**Nihon University Newcastle Campus (SSD-9787)  
Request for Additional Information**

I refer to the Response to Submissions (RtS) for the Nihon University Newcastle Campus (SSD-9787). After careful consideration, the Department is requesting that you provide additional information.

Project	P1626 Nihon University Newcastle Campus			Scale 1:200 at A3
Date	23/10/2019	Prepared By	SL	
Drawing No.	SS01	Revision	A

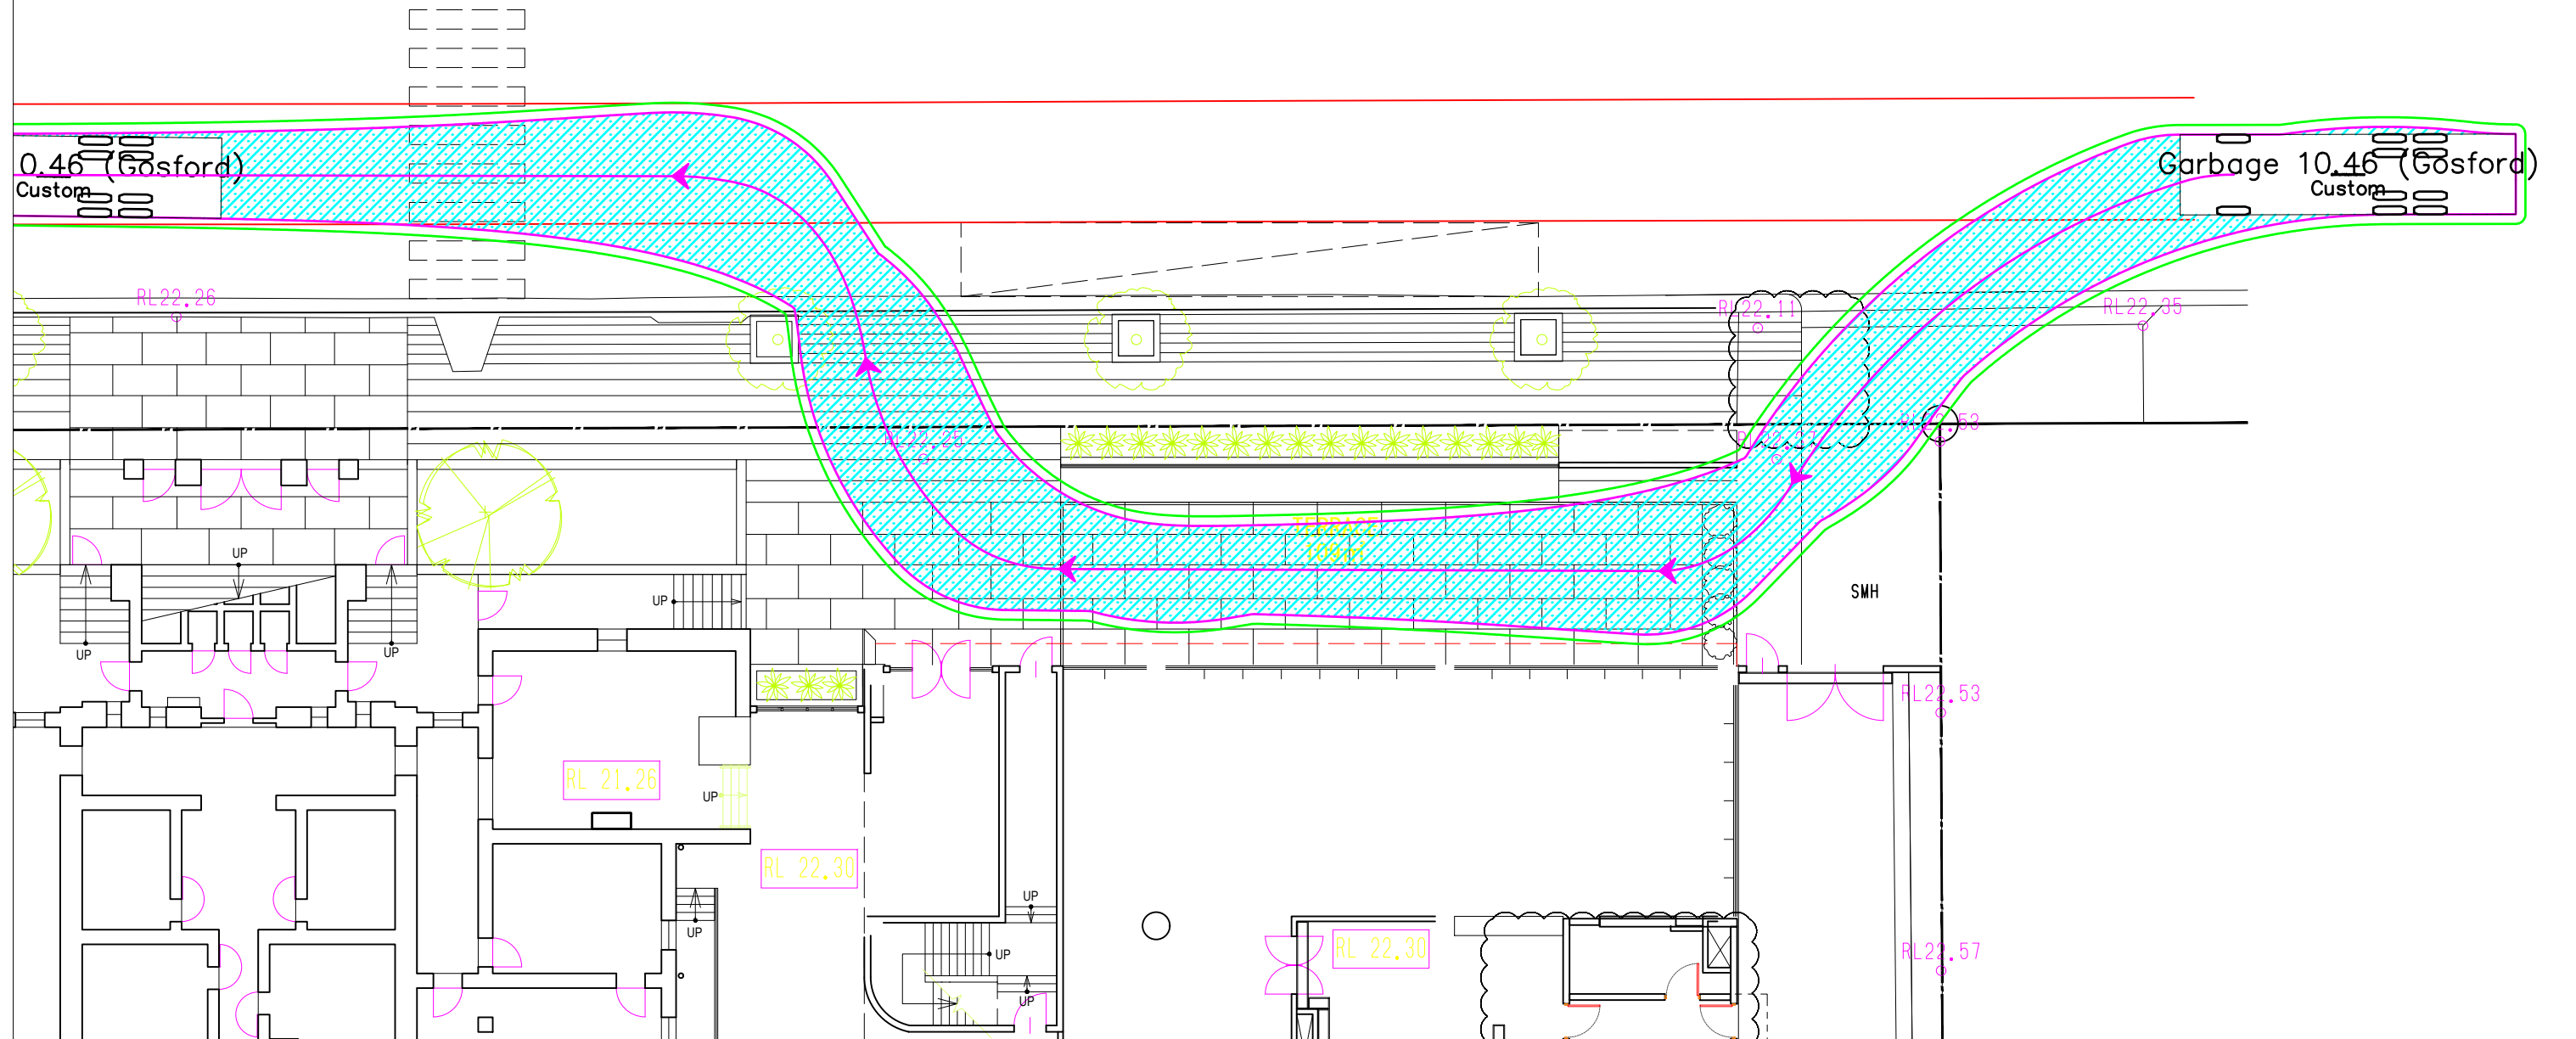
- identify measures to address the vehicle access/servicing arrangements as Council has advised that it does not support the proposed on-street arrangements.
- provide interim site auditor advice to confirm that the proposed approach regarding contamination is appropriate for the site and to confirm that the site can be made suitable for the proposed use.
- submit the full Aboriginal Cultural Heritage Assessment Report, as recommended for preparation in the *Aboriginal Cultural Heritage Assessment* prepared by Archaeological Management and Consulting Group and Streat Archaeological Services Pty Ltd, dated July 2019.
- clarify whether there would be any public use of the cafeteria.
